1
SITE PLAN
 Scale: 1:900
 (1" = 75')

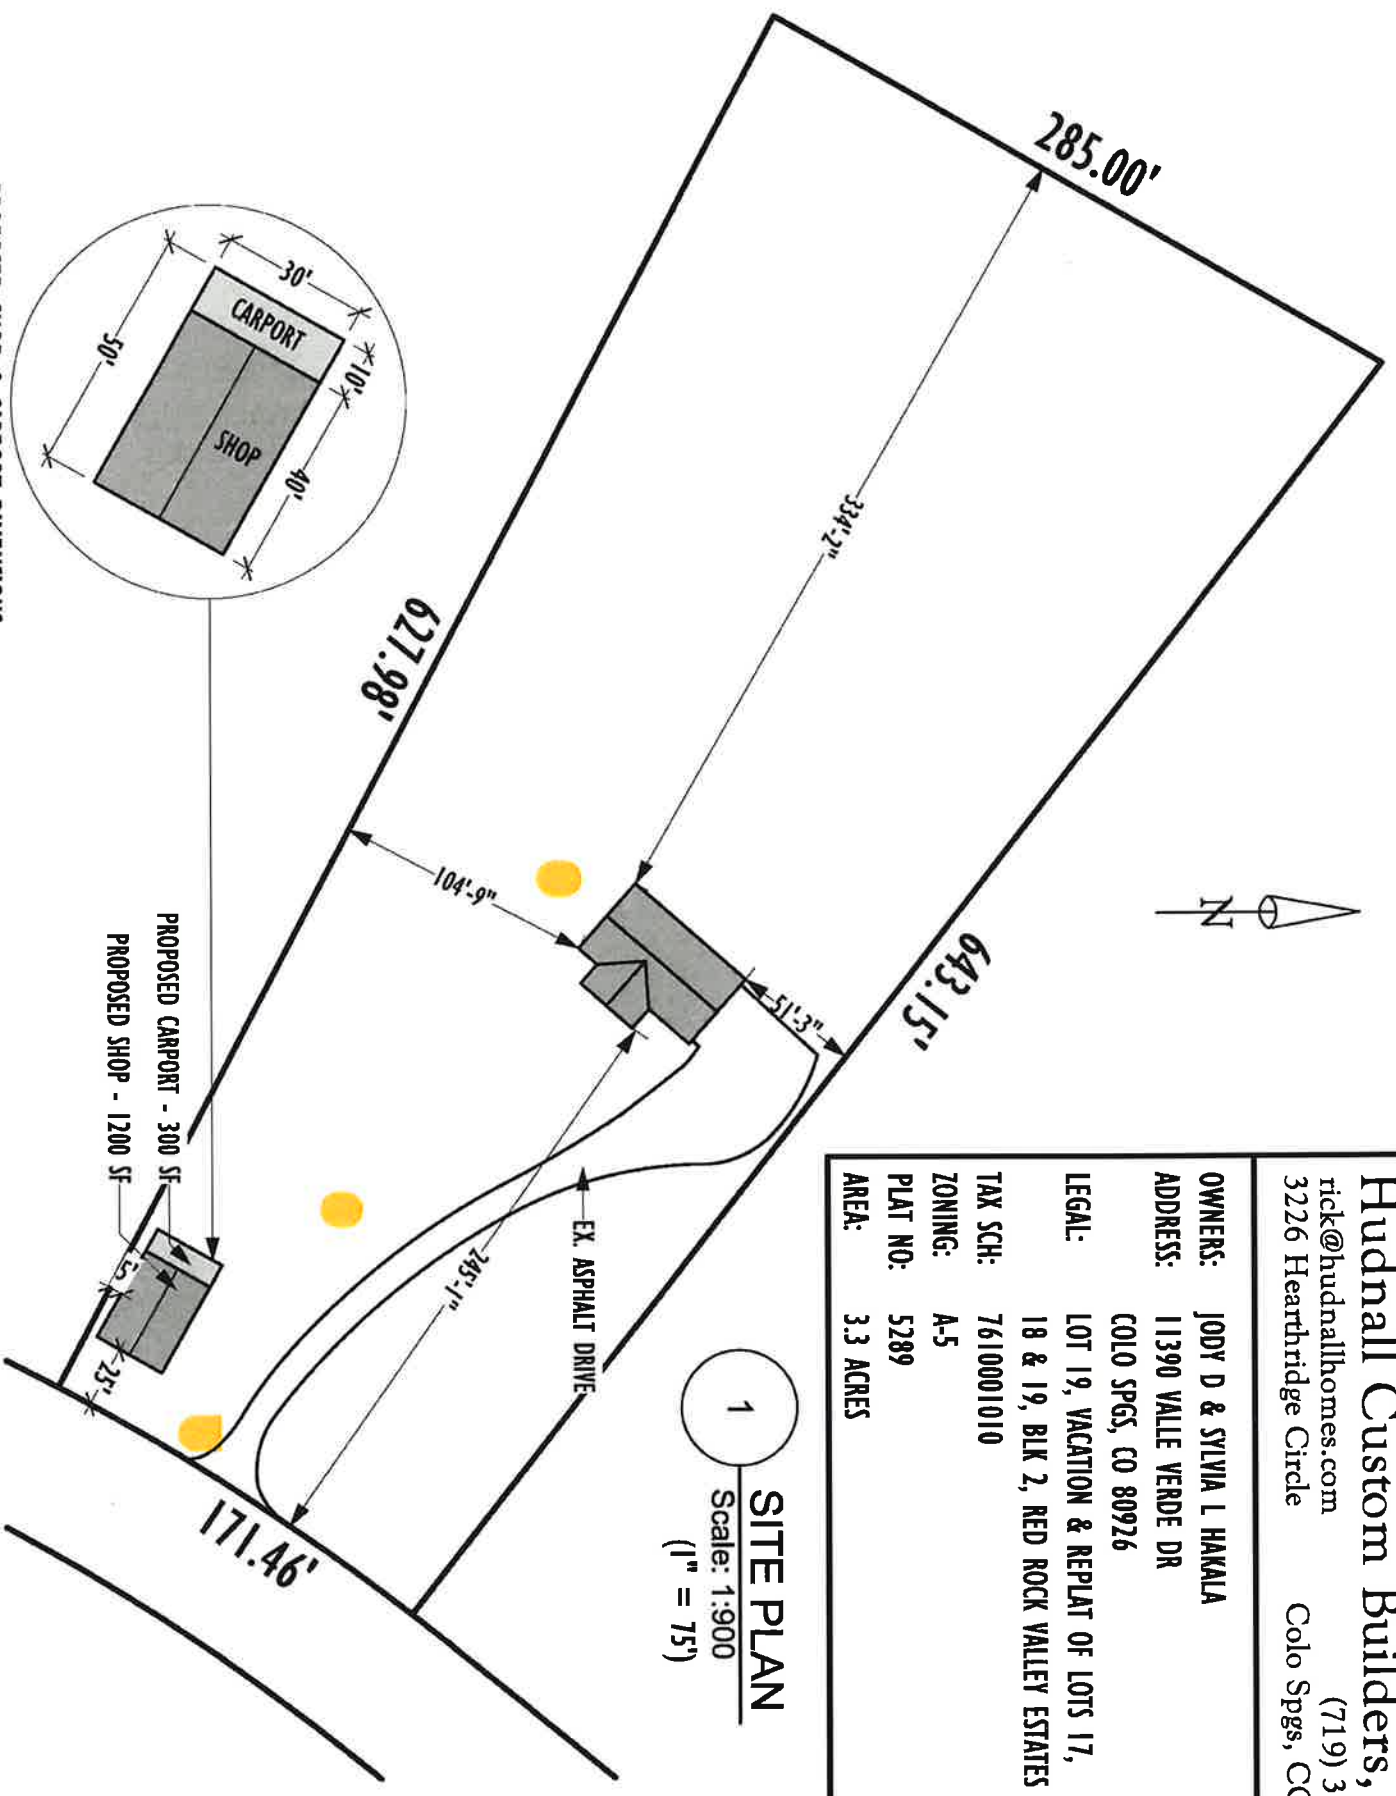
Please add the following to the site plan:  
 -owner telephone and email

Please show the proposed driveway

Please add the following to the site plan:  
 - "PCD File NO. BOA215"  
 - Name of the adjacent road "Valle Verde Dr"  
 - Note: The property frontage along Valle Verde Dr does not meet the minimum requirements for a second access onto Valle Verde Dr.
